DEVELOPMENT REVIEW BOARD TRANSPORTATION DEVELOPMENT Standard Comment Sheet

DRB-1002710

RE :North Albuquerque Acres, Unit 3

DESCRIPTION OF REQUEST: Sketch Plat Approval for Ventruea Subdivision

SKETCH PLAT

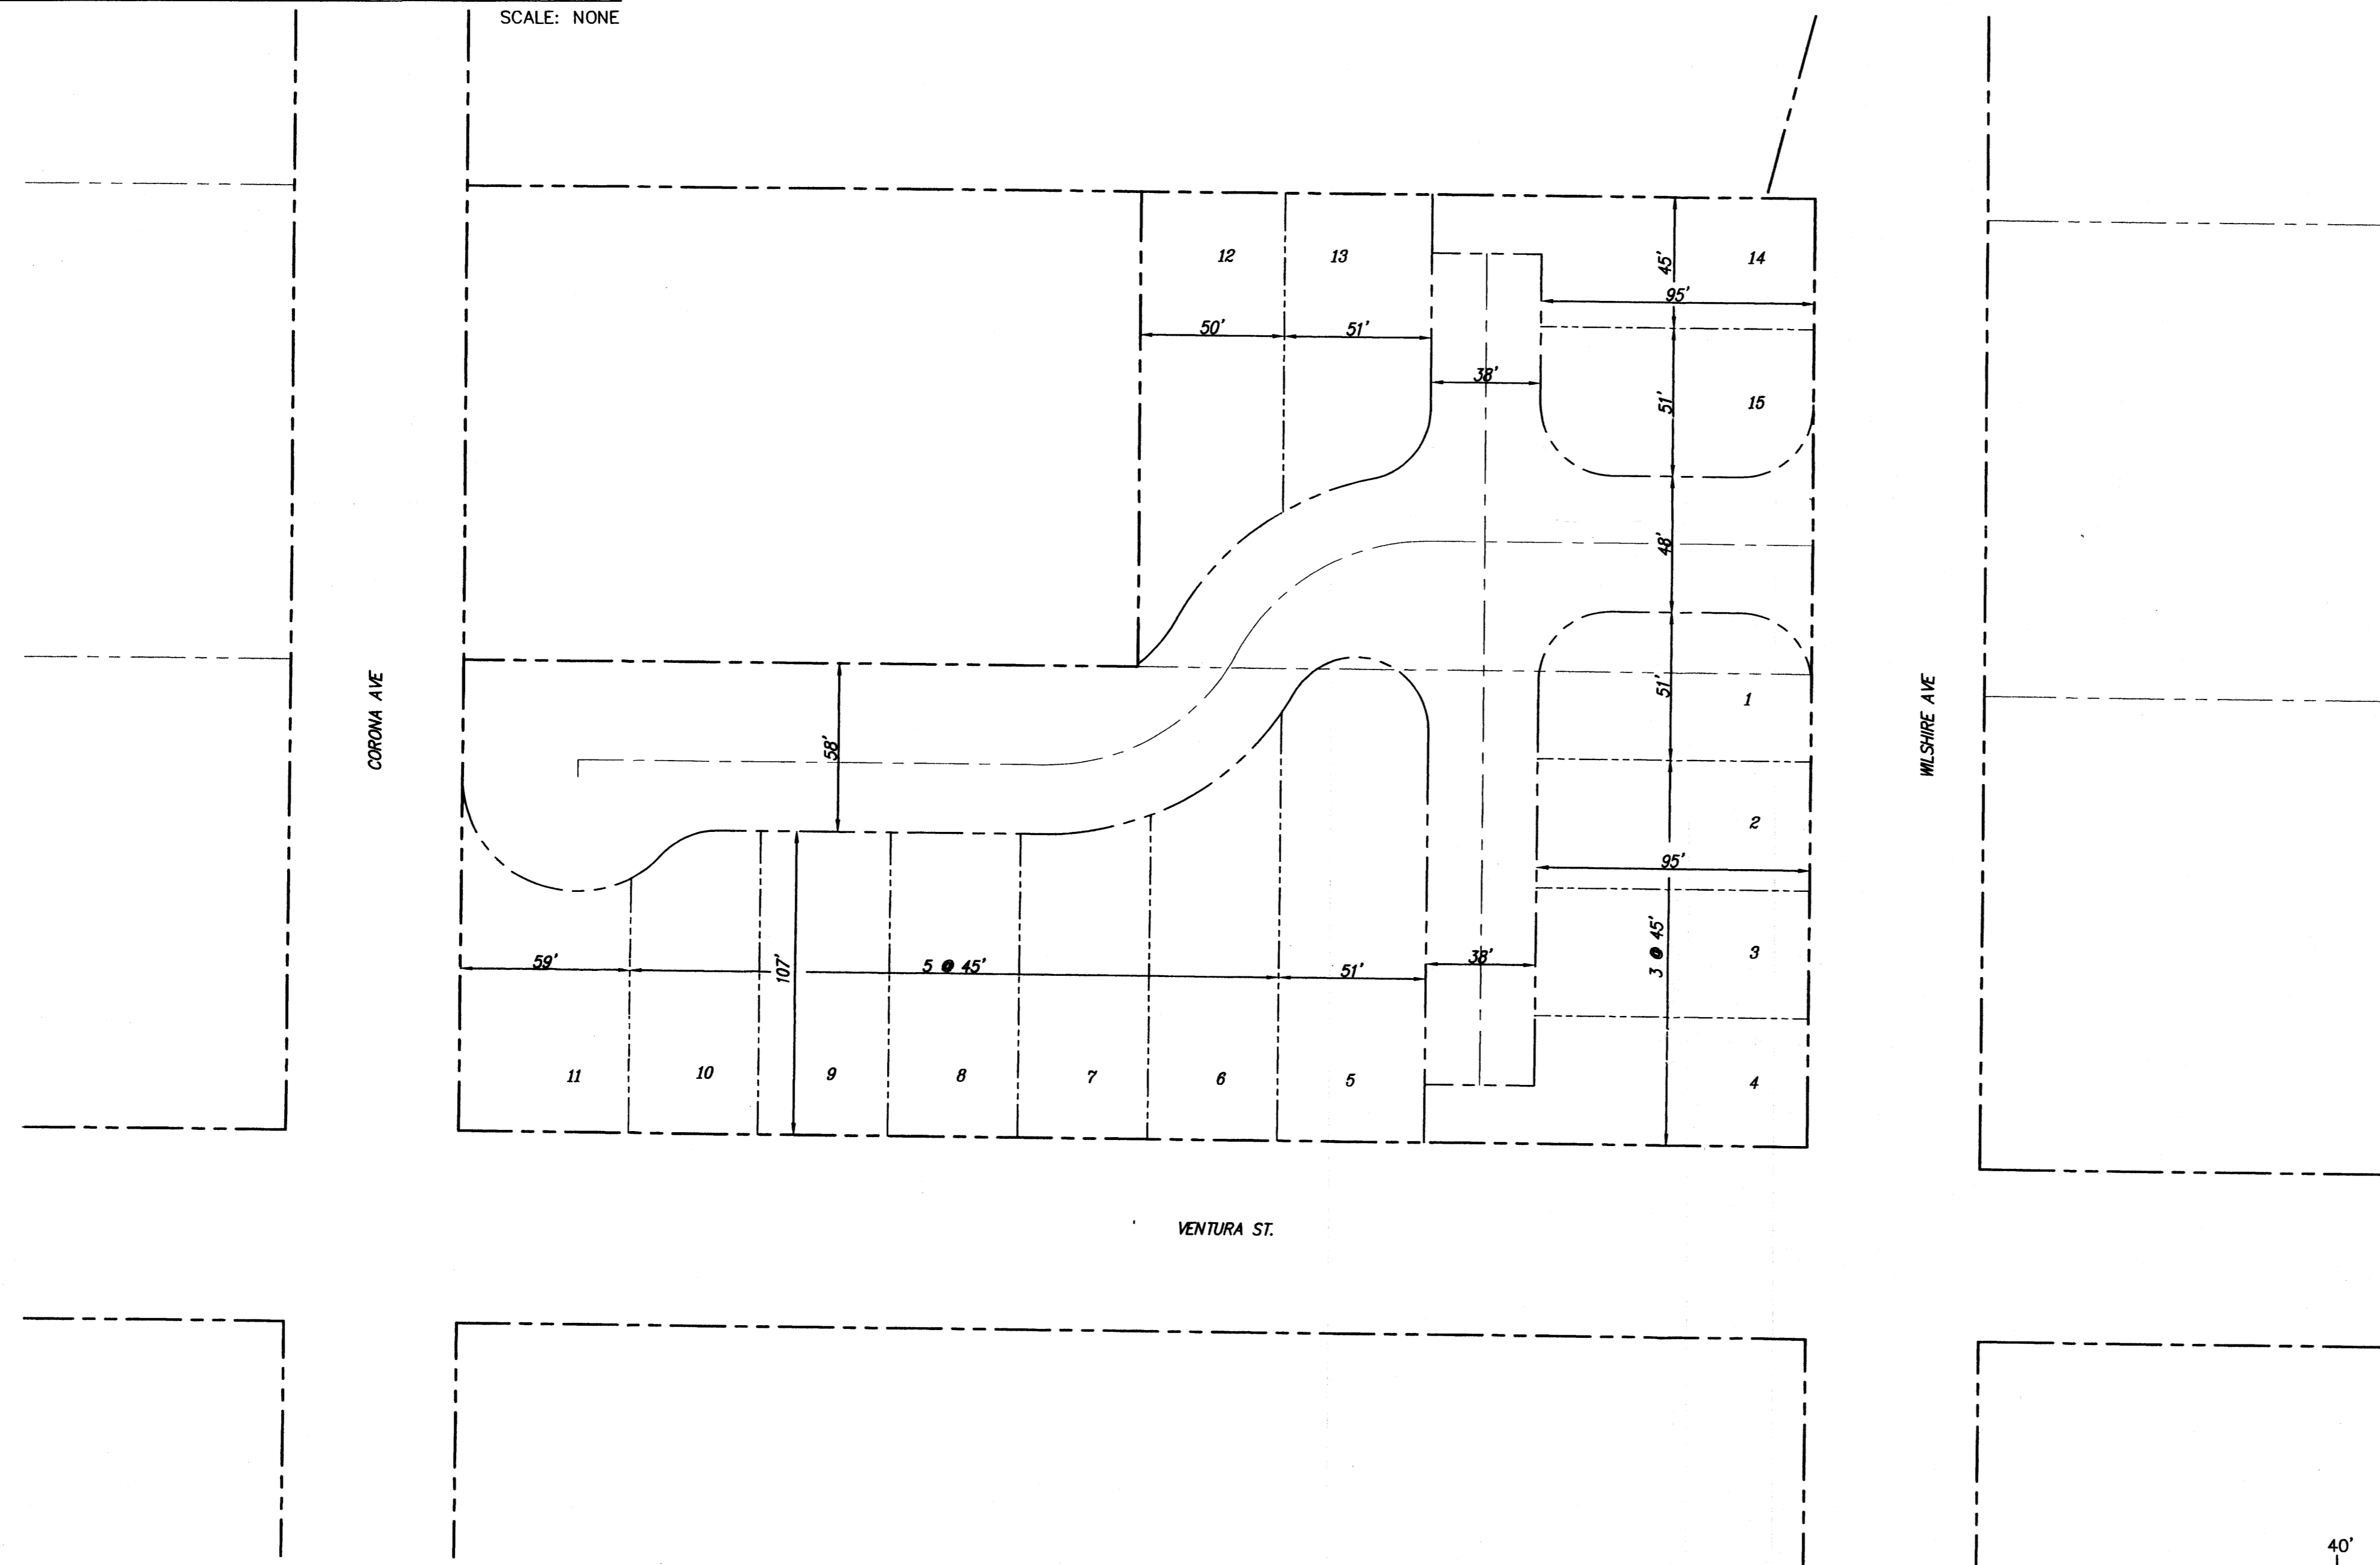
- The standard street improvements are required on an infrastructure list.
- The streets need to meet the requirements of the DPM.
- A traffic distribution layout is needed.
- Ventura right-of-way dedication is needed, likely to be 19ft.

An approved drainage report is required for Preliminary Plat approval.
An approved infrastructure list is required for Preliminary Plat approval.
Development projects with land area of 1 acres, or more, are required to file a Notice of Intent (NOI) with the US Environmental Protection Agency for storm water discharge during construction.

The Vineyard Sector Plan does not require a site development plan for RD zoning developed as single family units or townhouses. Since this development will occur in a sector plan area without an approved site plan, be sure to follow the RT lot size & setback requirements when planning the development.
